PART 3A MAJOR PROJECT APPLICATION SUBMISSION BY KU-RING-GAI COUNCIL

SUMMARY SHEET

PROPOSAL:	132 - 138 Killeaton Street, St Ives – Erection of 5 x 5 storey residential flat buildings containing 298 units, basement carparking, adaptive re-use of existing monastery building for communal facilities, landscape works, strata subdivision and staged construction/occupation
WARD:	St Ives
APPLICATION N^o:	MP 10_0057
SUBJECT LAND:	132 to 138 Killeaton Street, St Ives
APPLICANT:	Karimbla Properties (No.4) Pty Ltd – Meriton
OWNER:	Dasmin Pty Ltd
DESIGNER:	Meriton Apartments Pty Ltd
PRESENT USE:	Vacant, former monastery building
ZONING:	R4 Residential
HERITAGE:	No
PERMISSIBLE UNDER:	Ku-ring-gai LEP (Town Centres) 2010
COUNCIL'S POLICIES APPLICABLE:	Ku-ring-gai LEP (Town Centres) 2010 Ku-ring-gai DCP (Town Centres) 2010 Ku-ring-gai Section 94 – Development Contribution Plan 2004 – 2009 Residential Development (Amendment 2) Ku-ring-gai Town Centres Development Contributions Plan 2008
GOVERNMENT POLICIES APPLICABLE:	NSW State Plan 2010 Draft North Subregional Strategy Metropolitan transport Plan 2010, Integrating Land Use and Transport – A Planning Policy Package 2001 and Planning Guidelines for

CARPARK STAGE-2
SCALE 1:500

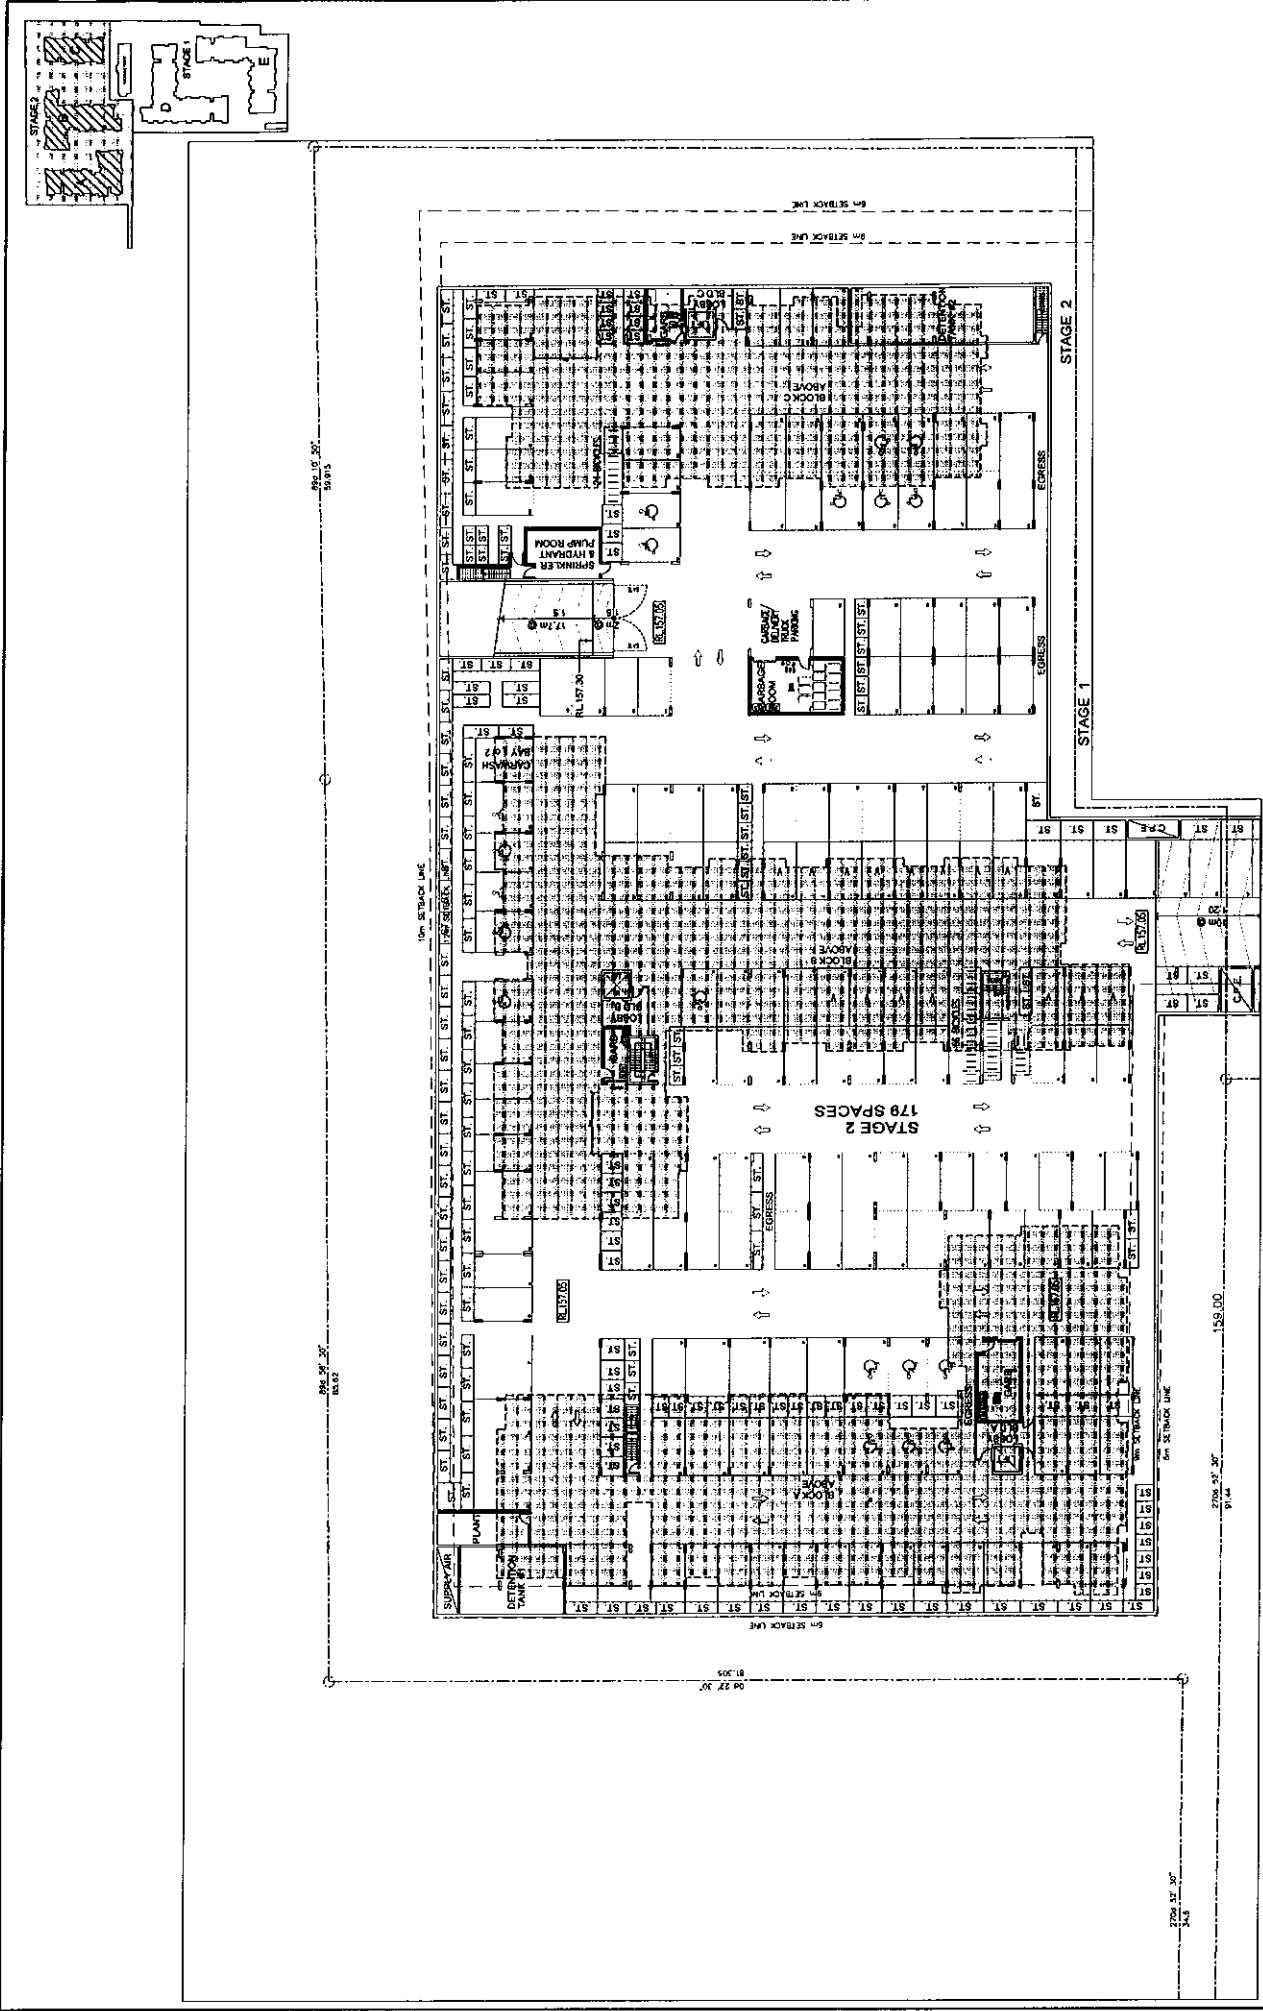
- Basement car park design: single level carpark covers extensive area and significantly reduces opportunities for deep soil landscaping, safety issues also raised

- Non-compliance with minimum carparking requirements, shortfall of 44 visitor parking spaces and over-supply of residential spaces
- Basement not dimensioned to assess against relevant AS requirements (parking spaces and aisle dimensions)
- Inappropriate location of driveway access in relation to sight distance
- Unsatisfactory construction management plan

The proposed single-level basement car park which covers an extensive area of the site would significantly reduce the opportunities for deep soil landscaping. This car parking layout would also decrease the perceptions of safety having to travel longer between some parking and the lift core. The basement should be extended to at least two levels and be consolidated under building footprints to maximise the deep soil landscaping area, thereby contributing to the tree canopied character and the biodiversity of the locality.
